LSC RESPONSES TO EPC TIS REDLINE COMMENTS

Mr. John Mick
Mayberry Phase 1

October 22, 2021
Transportation Memorandum

### TYPICAL ROAD SECTION & DETAILS

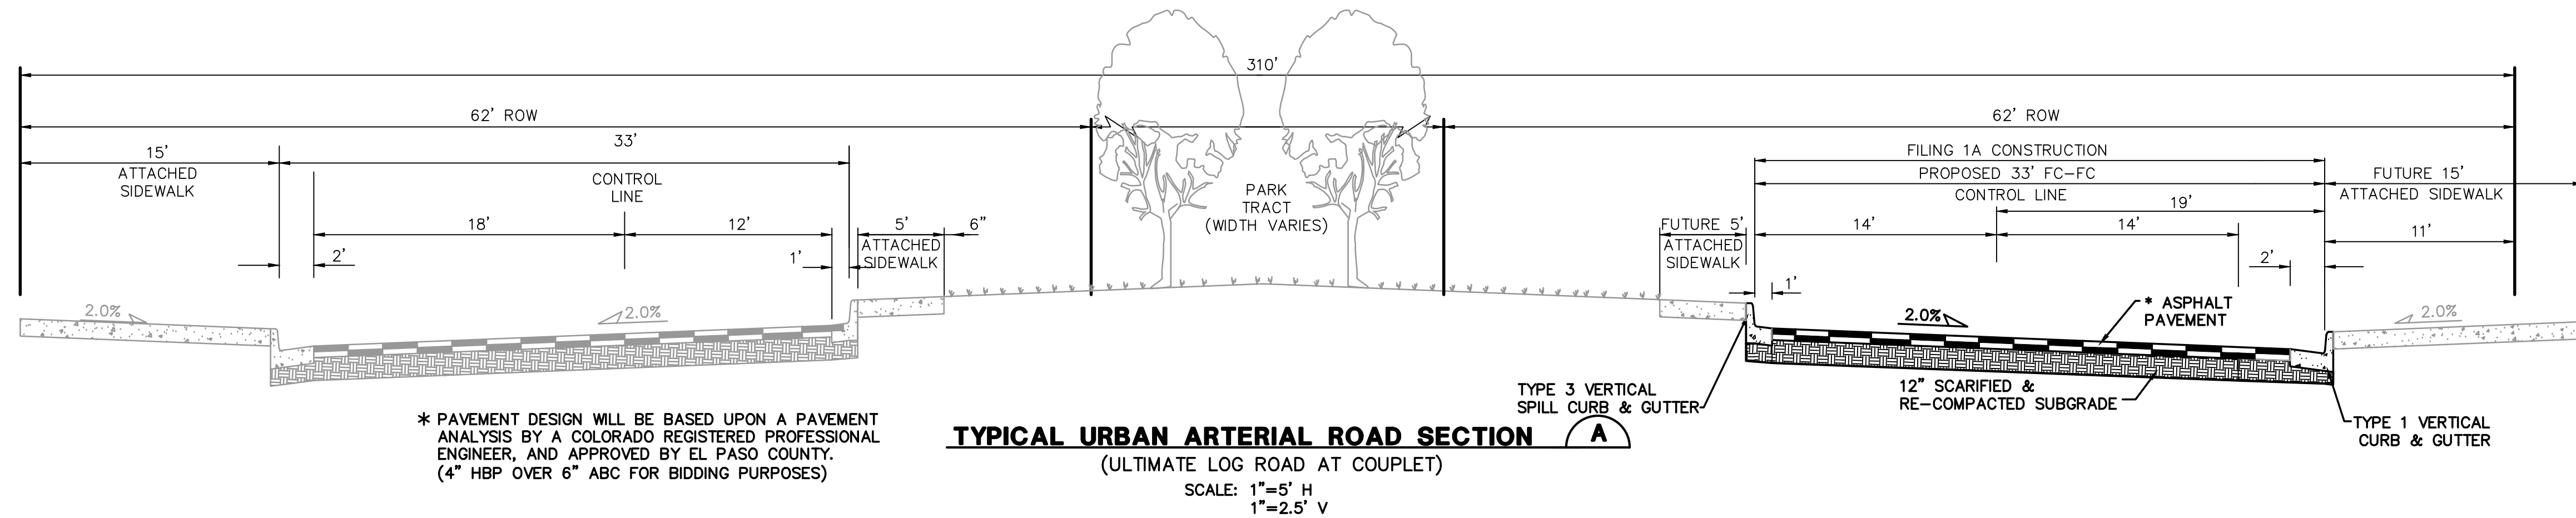
Please identify that the ROW provided is still 60' for the segment through the residential areas (matching the previous deviation) and that the urban local roadway also identifies a 30 ft. asphalt width. If there are any differences in the proposed roadway section please identify them for review.

LSC Response: The TIS report has been updated to address this comment.

FILING 2-4 PRE-DEVELOPMENT
GRADING & EROSION CONTROL PLAN

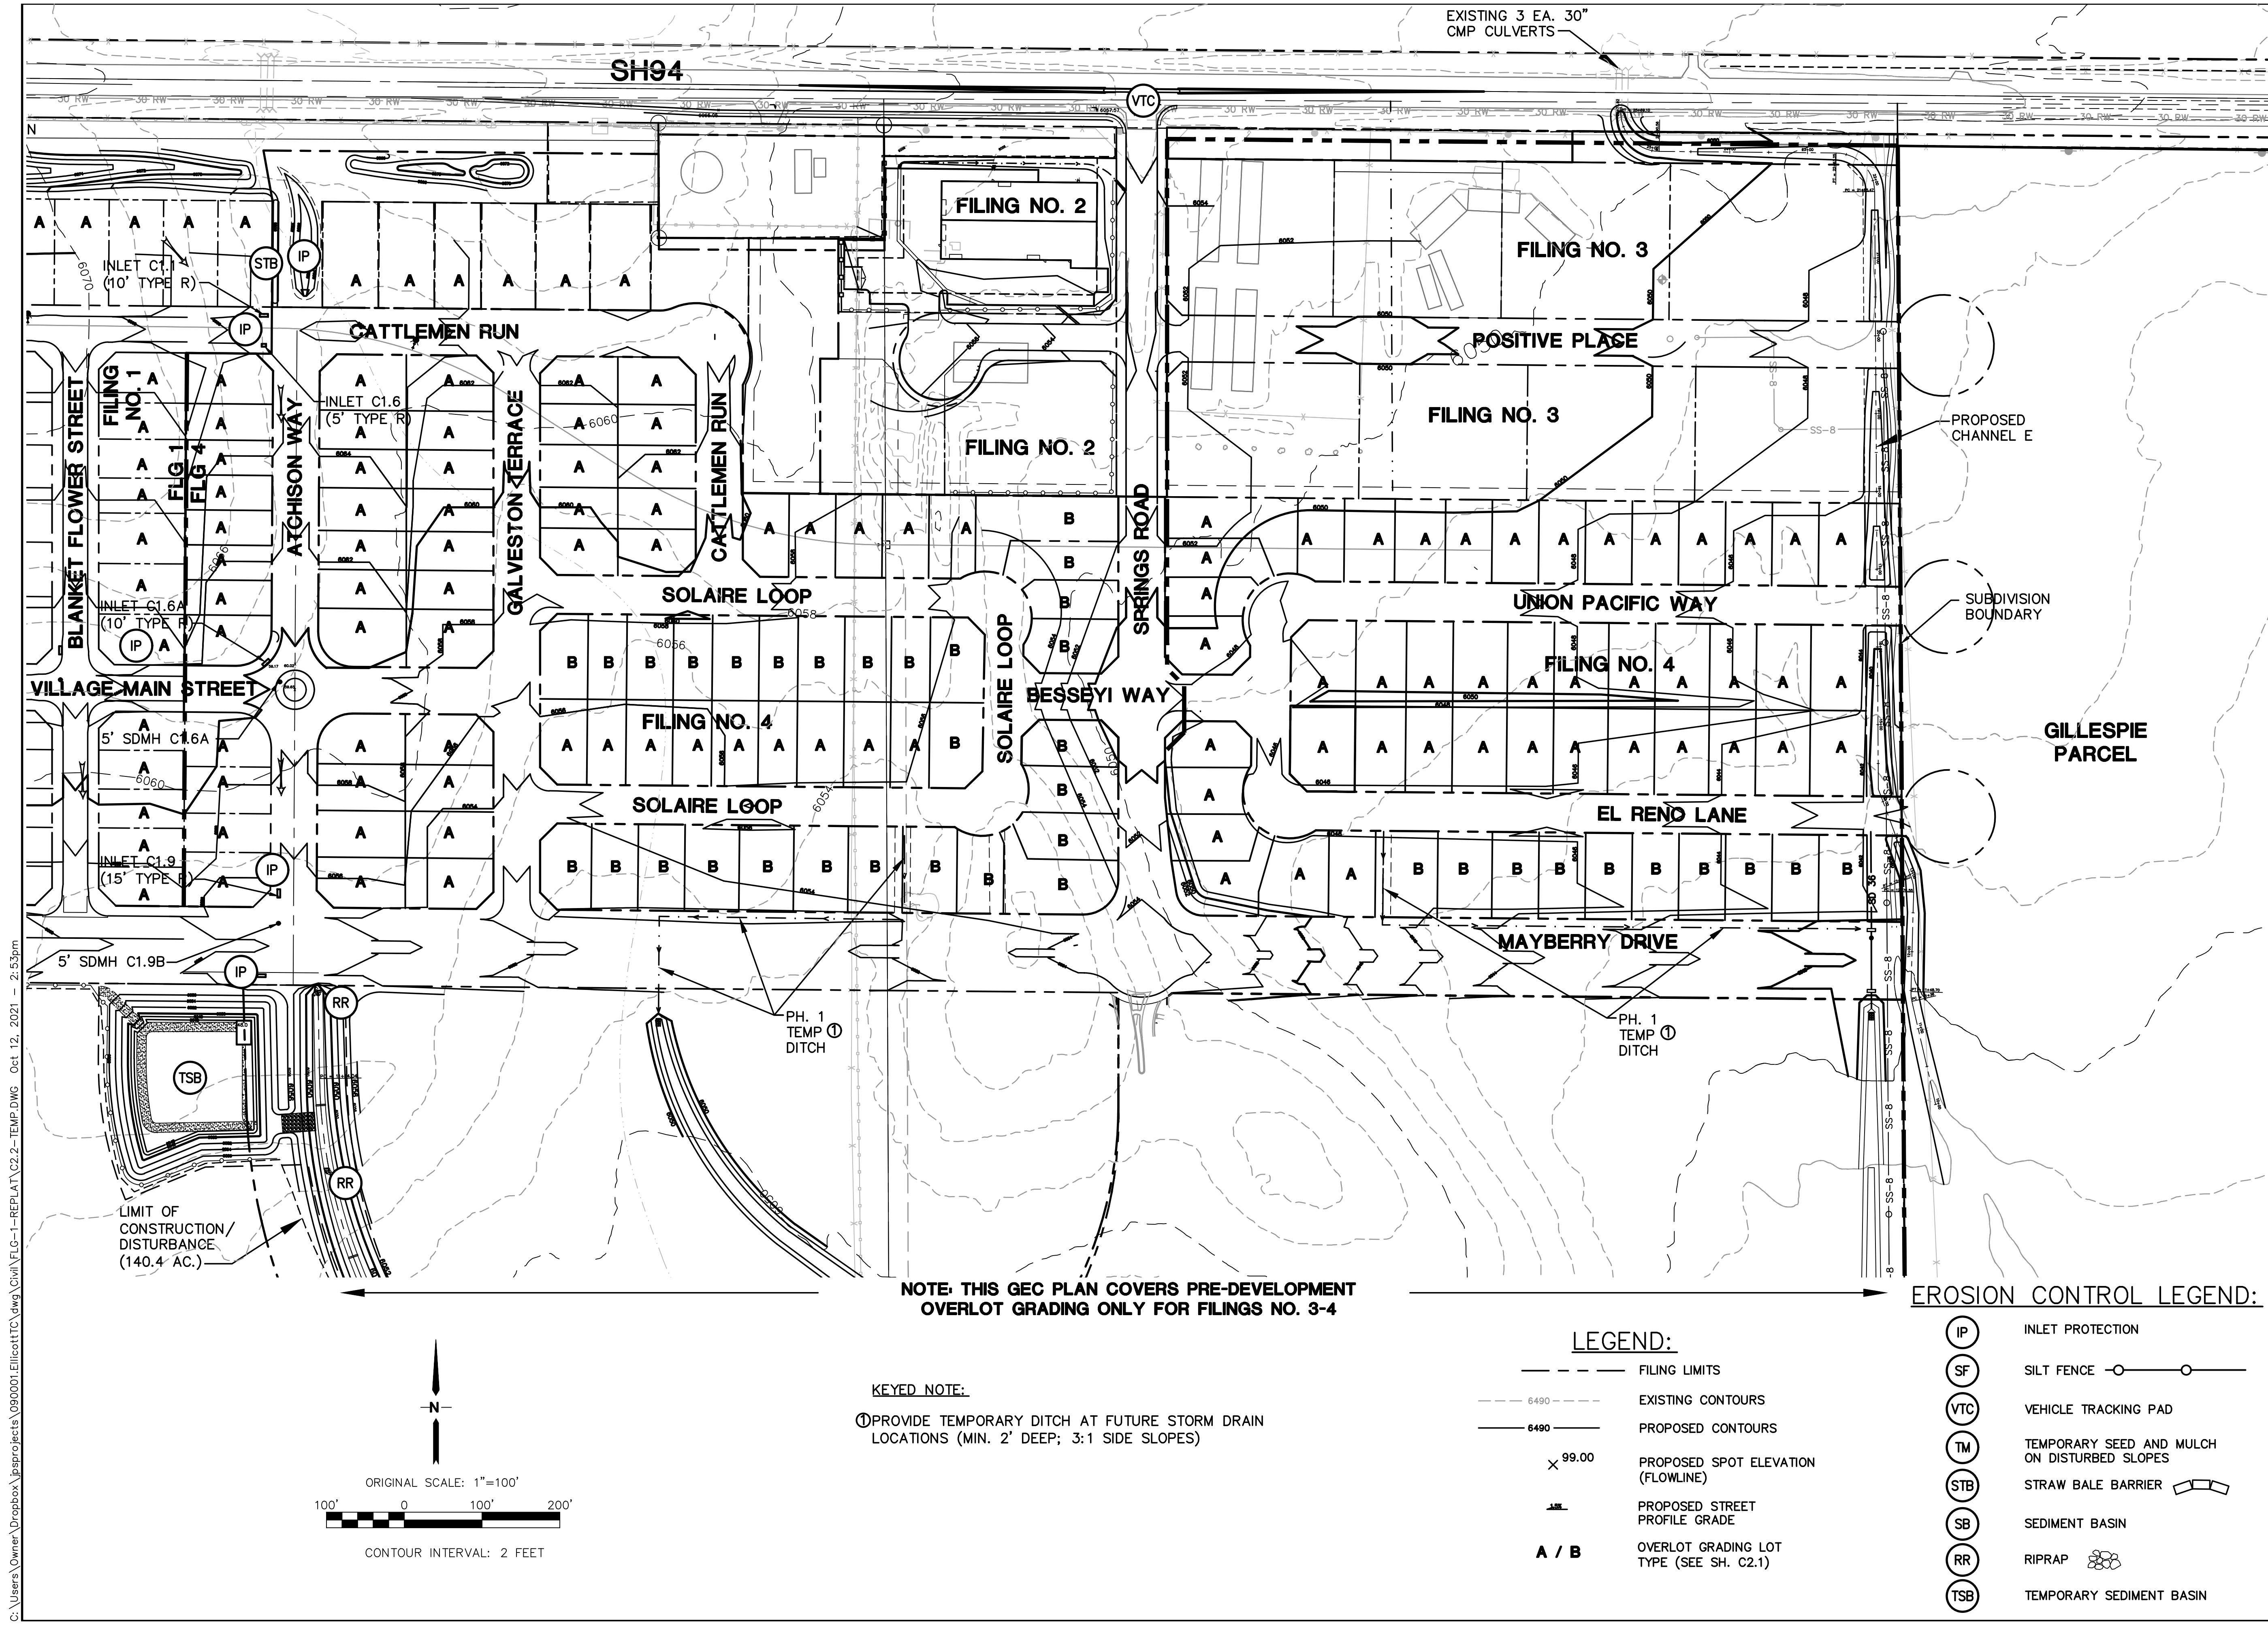
Please coordinate with the civil engineer and planner as the pre-development grading plan proposed with this application shows overlot grading of lots and rough cut of the roadways of filing 4 such that Village Main does not connect to Springs road.

LSC Response: The coordination has occurred and the report has been updated accordingly.
